REF	KIRKLEES METROPOLITAN COUNCIL TOWN AND COUNTRY PLANNING ACT 1990 2016/60/91761/E0/WS	PLANNING
	HIGHWAYS DEVELOPMENT CONTROL Minor KP20H	CATEGORY
No.	PROPOSAL K11-12SE/11	HDC Ref.
Officer	Alistair McMurray	Highway
	OUTLINE APPLICATION FOR ERECTION OF ONE DWELLING	O. S. Ref.
Received	187 151 24/06/2016	Date
Date	LOCATION 01/07/2016	Target
Returned	08/07/2016	Date
	ADJ 83 COMMON END LANE LEPTON HUDDERSFIELD HD8 0AF	Route No.
	Unclassified APPLICANT COMMON END LANE	Road Name
	FARRAR BAMFORTH ASSOCIATES	Adopted
	Yes	Footpath
	KIR63-10	Footpath
	pro w emailed 24/6/16	Highway
scheme	Yes	IL 240
/ date	Sam Lewis 24/06/2016	Checked by

This is an outline application for which only access is being considered.

Proposed Site Layout

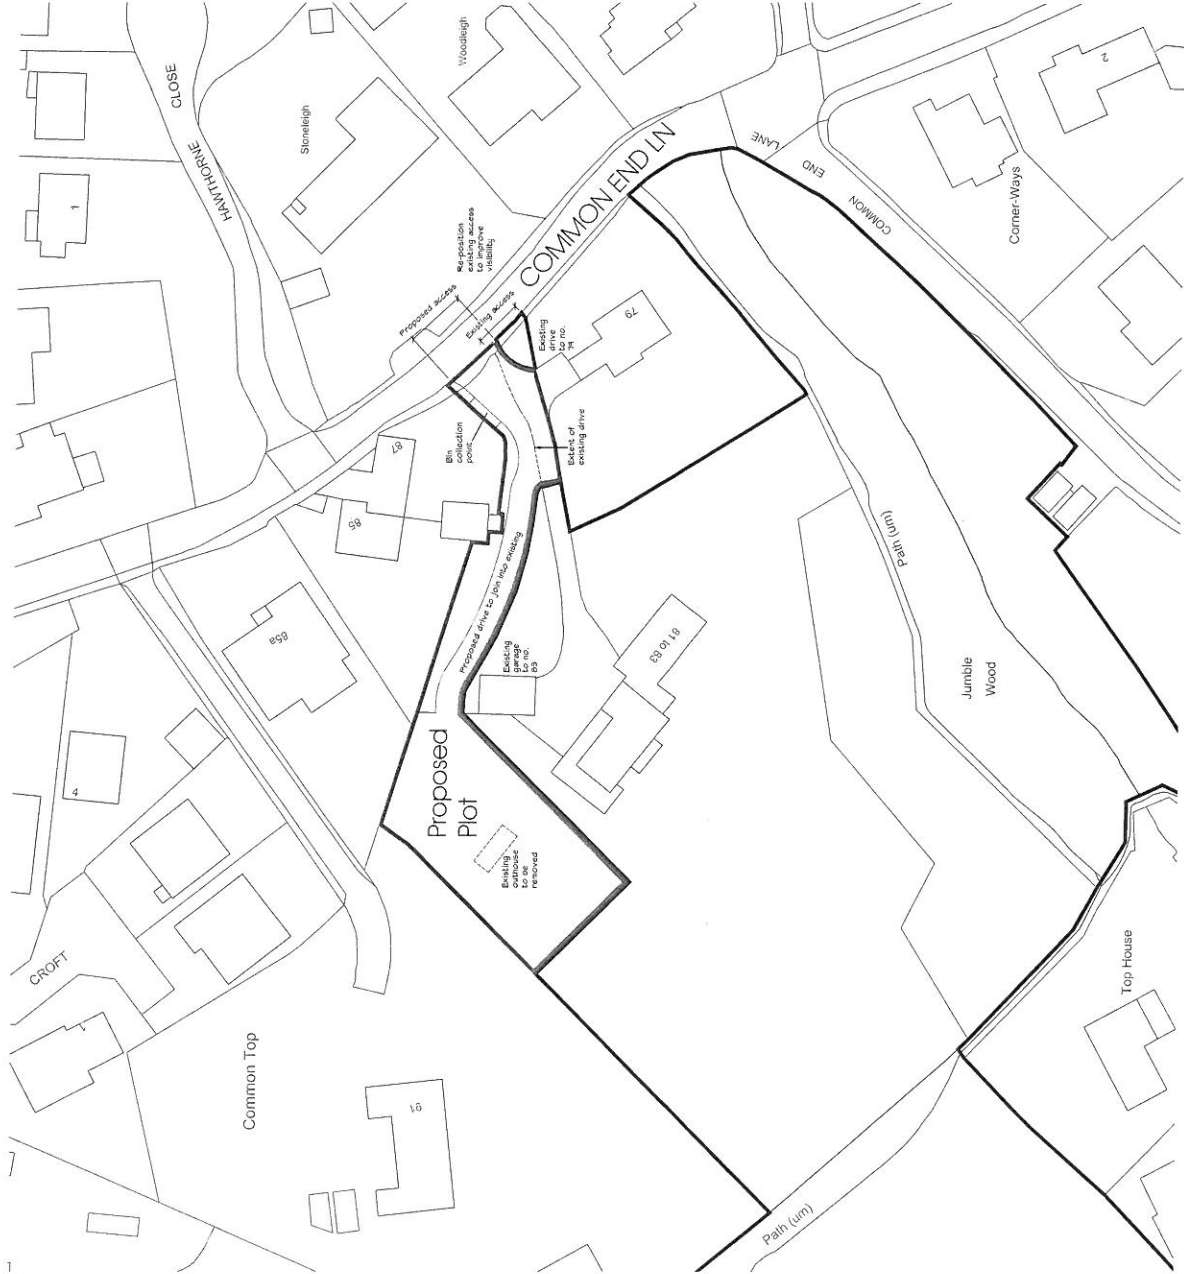
The submitted plans illustrate that the existing access is to be widened and relocated to the northwest in order to improve visibility. As access is to be determined, the submitted plans should demonstrate the vehicular visibility splays that are now being achieved from the relocated access.
